Appeal Decision

Appeal Ref: APP/R5510/W/15/3065776

22 Deane Avenue, South Ruislip, Middlesex HA4 6SR

- The appeal is made under section 78 of the Town and Country Planning Act 1990 against a refusal to grant planning permission.
 - The appeal is made by Crown Lodge Developments Ltd against the decision of the Council of the London Borough of Hillingdon.
 - The application Ref 70505/APP/2014/4406, dated 13 December 2014, was refused by notice dated 3 March 2015.
 - The development proposed is demolition of existing bungalow and replacement with a new build block of 4 no. 2 bedroom flats.
-

drg title
ELEVATIONS, SITE PLAN & CYCLE / REFUSE / RECYCLING STORE

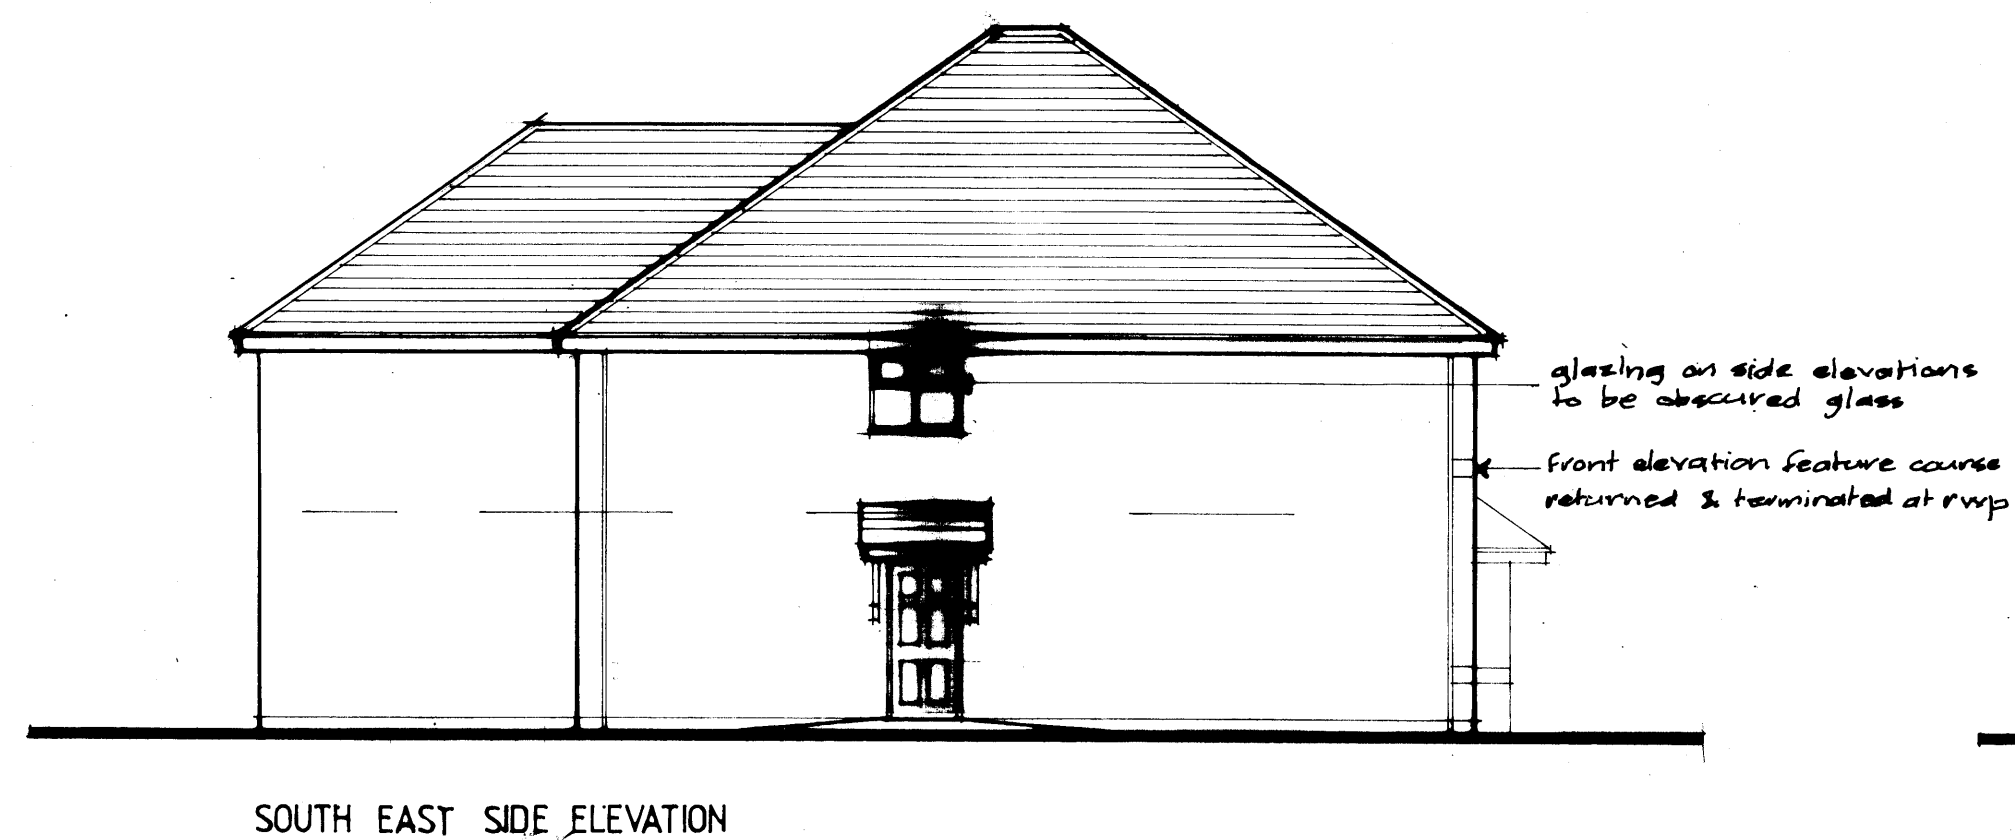
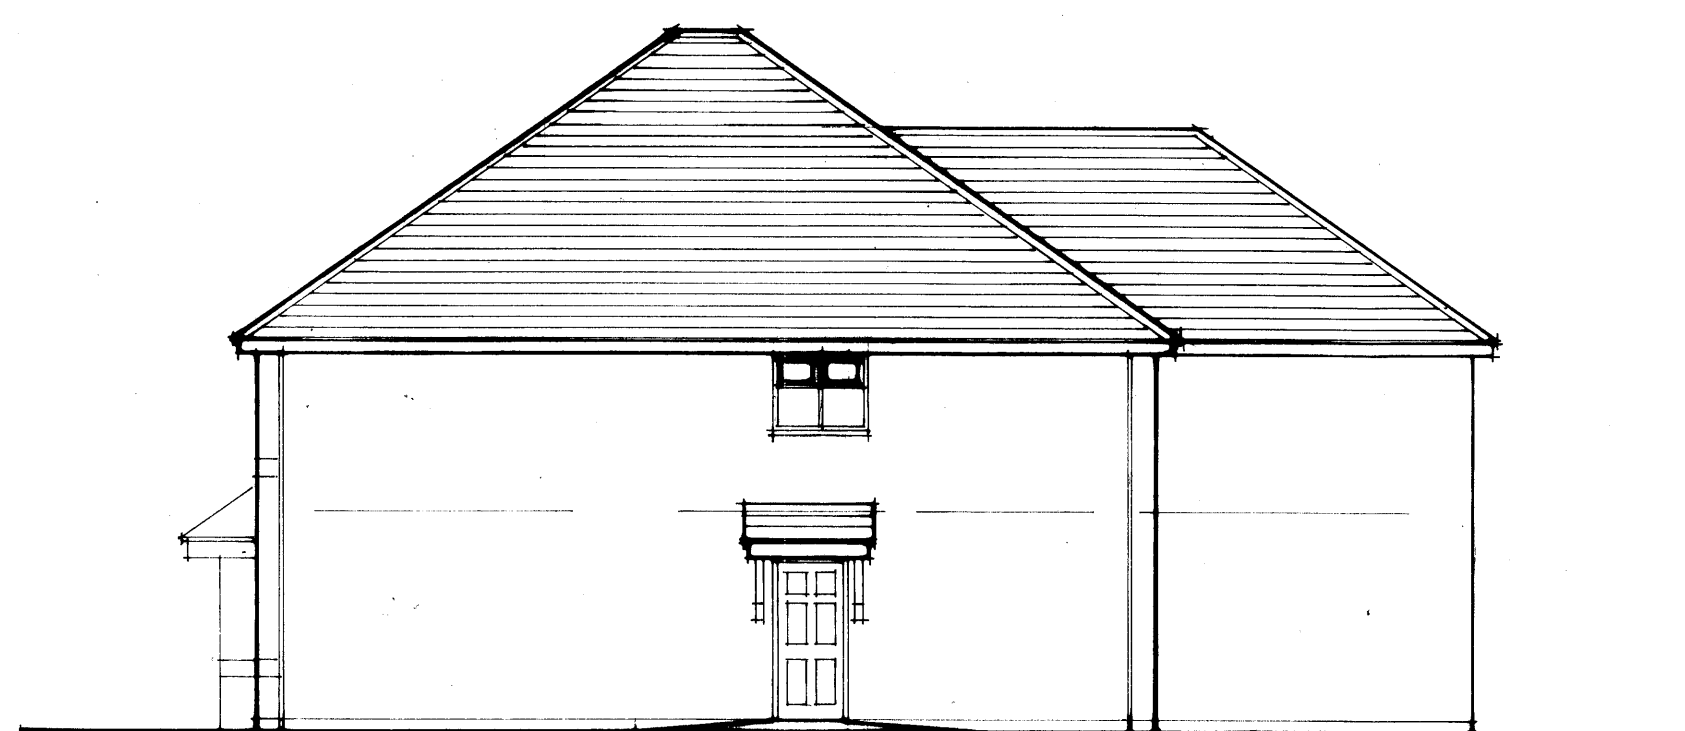
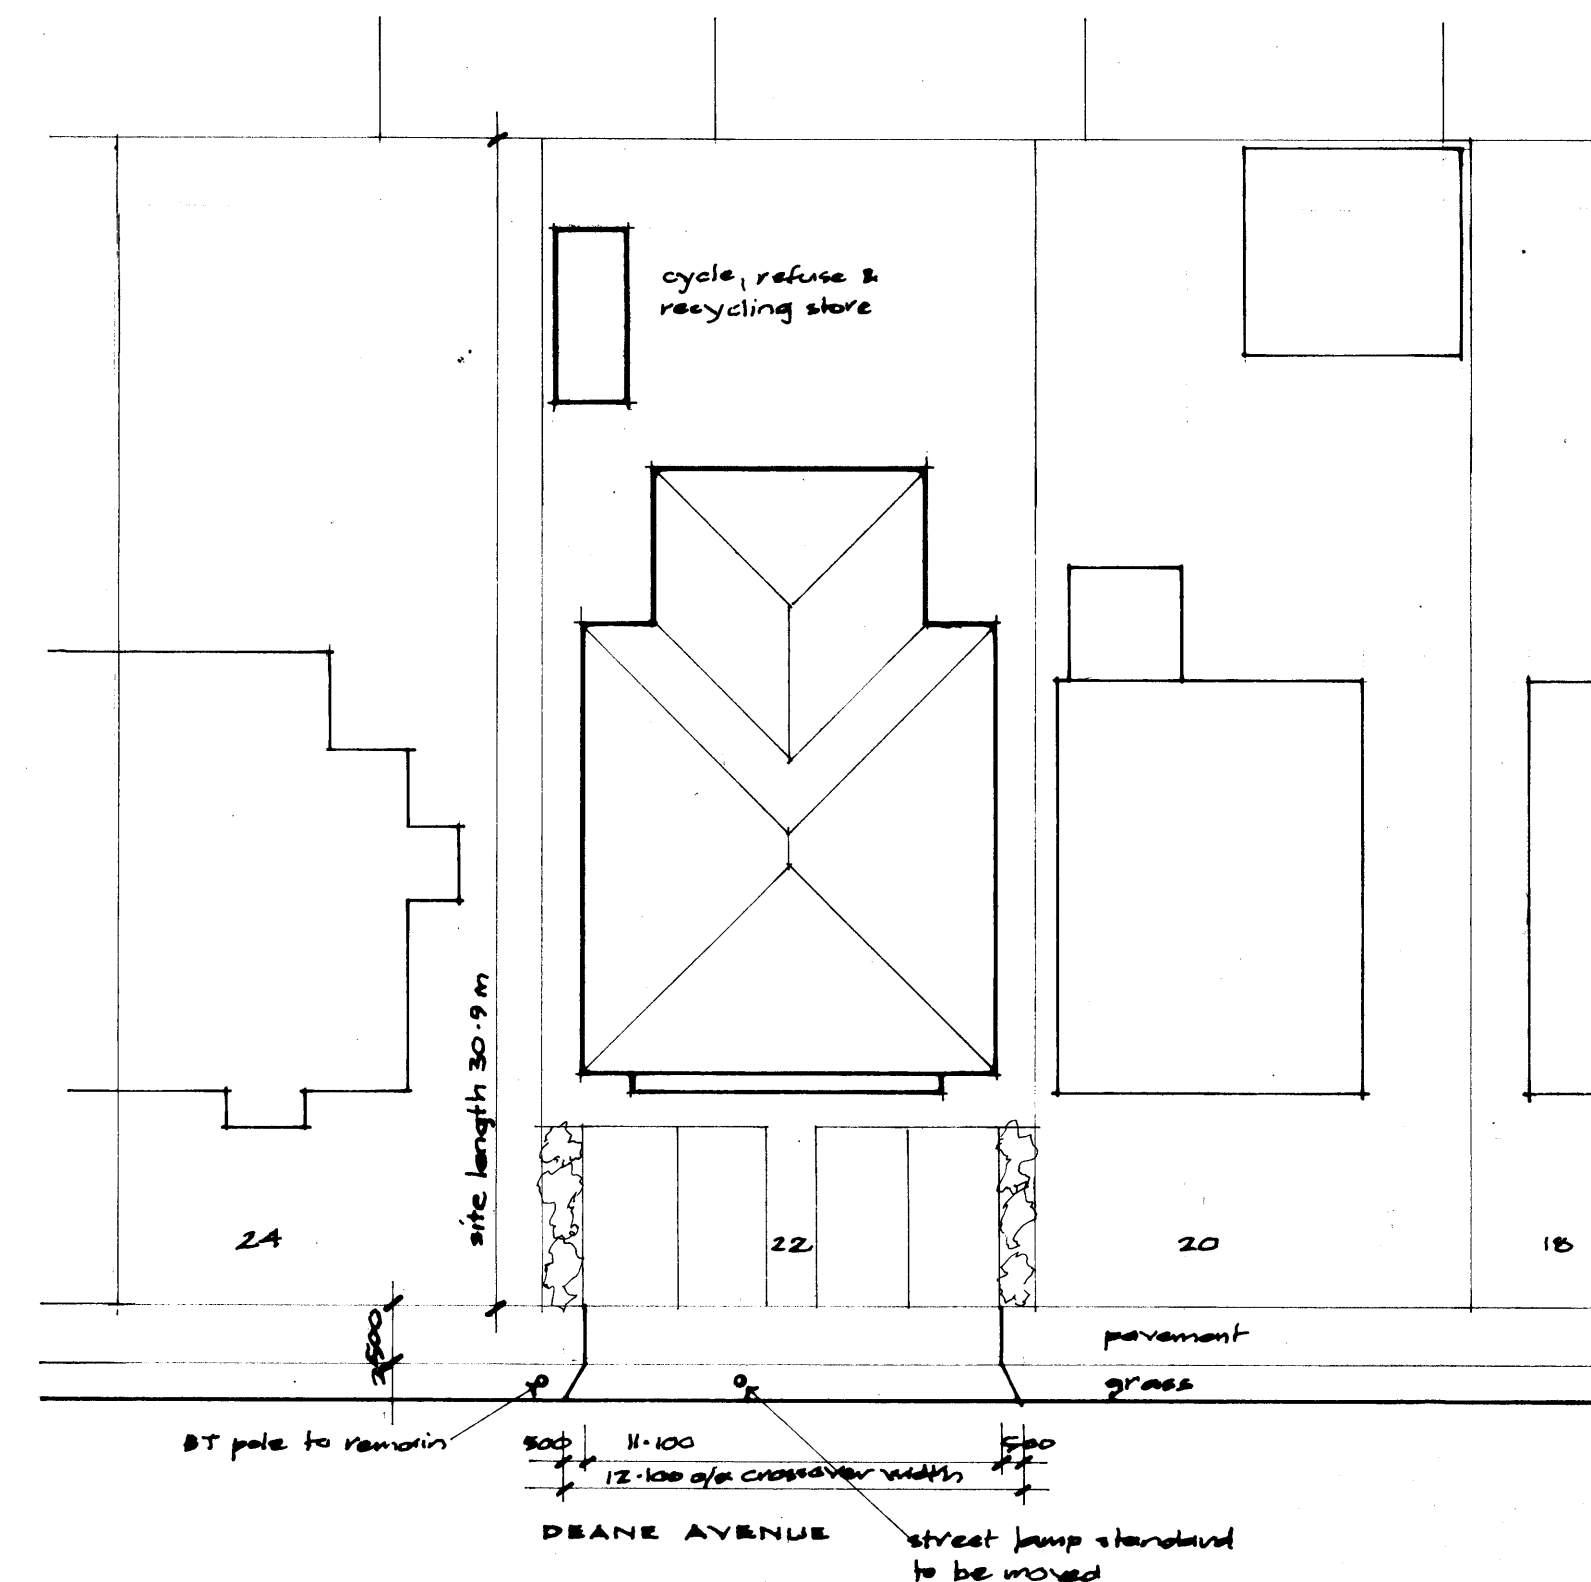
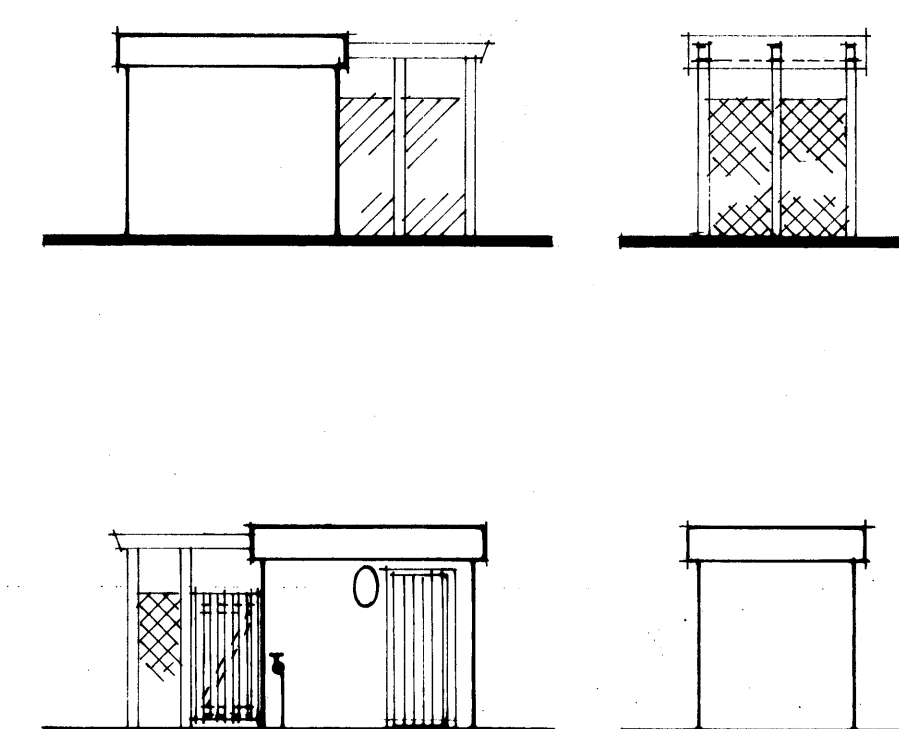
3. The proposed building would be significantly larger in footprint than the existing bungalow, covering a much greater proportion of the site and extending across most of the site frontage. Although similar in width to the bungalow and attached garage together, the proposal would be of significantly greater scale and bulk and its roof would be much higher than its neighbours and the other 2 storey dwellings in the street. The proposed building would result in a cramped development and would be over dominant and overbearing both within the site itself and in the street scene. It would leave only a minimal gap between the new building and number 20 Deane Avenue and the loss of this visual break between properties, the presence of which forms part of the character of the street, would interrupt the rhythm of the street scene.

4. The removal of the boundary wall and vegetation within the front garden and its replacement with hard surfaced parking would adversely affect the character and appearance of the street. The front gardens of a number of nearby properties have been surfaced for parking, although in many cases this has not involved the total loss of boundary walls/fences or garden vegetation, but I do

not consider that these should set any precedent. In my view the extent of hard surface and new vehicle crossover proposed, together with the lack of any opportunity for meaningful new landscaping on this frontage, would result in significant harm to the street scene.

CYCLE, REFUSE & RECYCLING STORE PLAN & ELEVATIONS

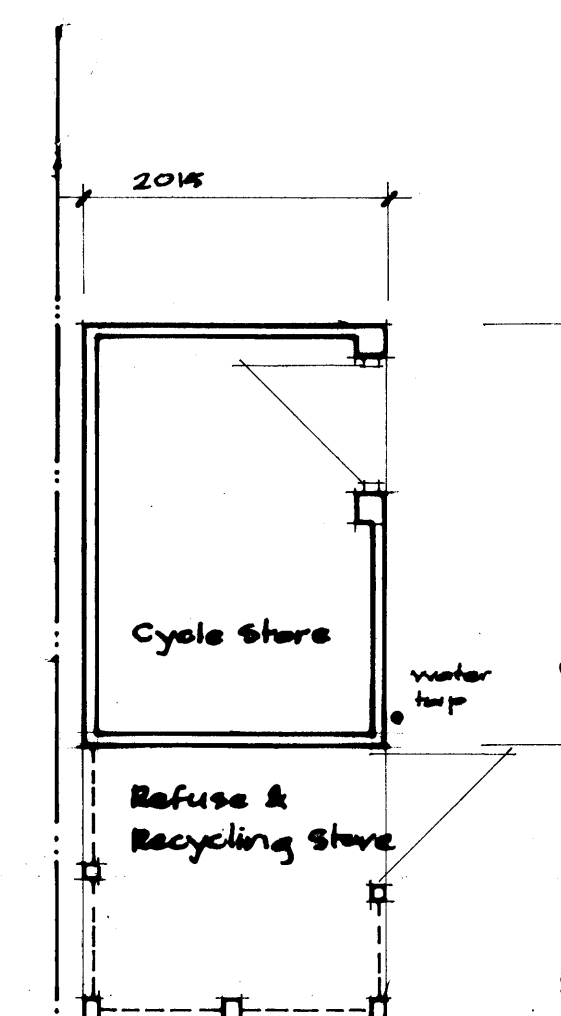
6. A shared cycle and bin store is proposed within the rear garden area which is to be used as a communal amenity space for the occupiers of the 4 flats. Given the location of the bedrooms to the ground floor flats these arrangements would give rise to a loss of privacy to the occupiers of those properties and some degree of noise and disturbance on a regular basis. I therefore conclude that the proposal would have adverse effects on the living conditions of the future occupiers of the ground floor accommodation and would conflict with Policies BE19, BE21 and BE24 of Part Two of the Hillingdon Local Plan which seek to ensure the privacy and amenity of residential occupiers.
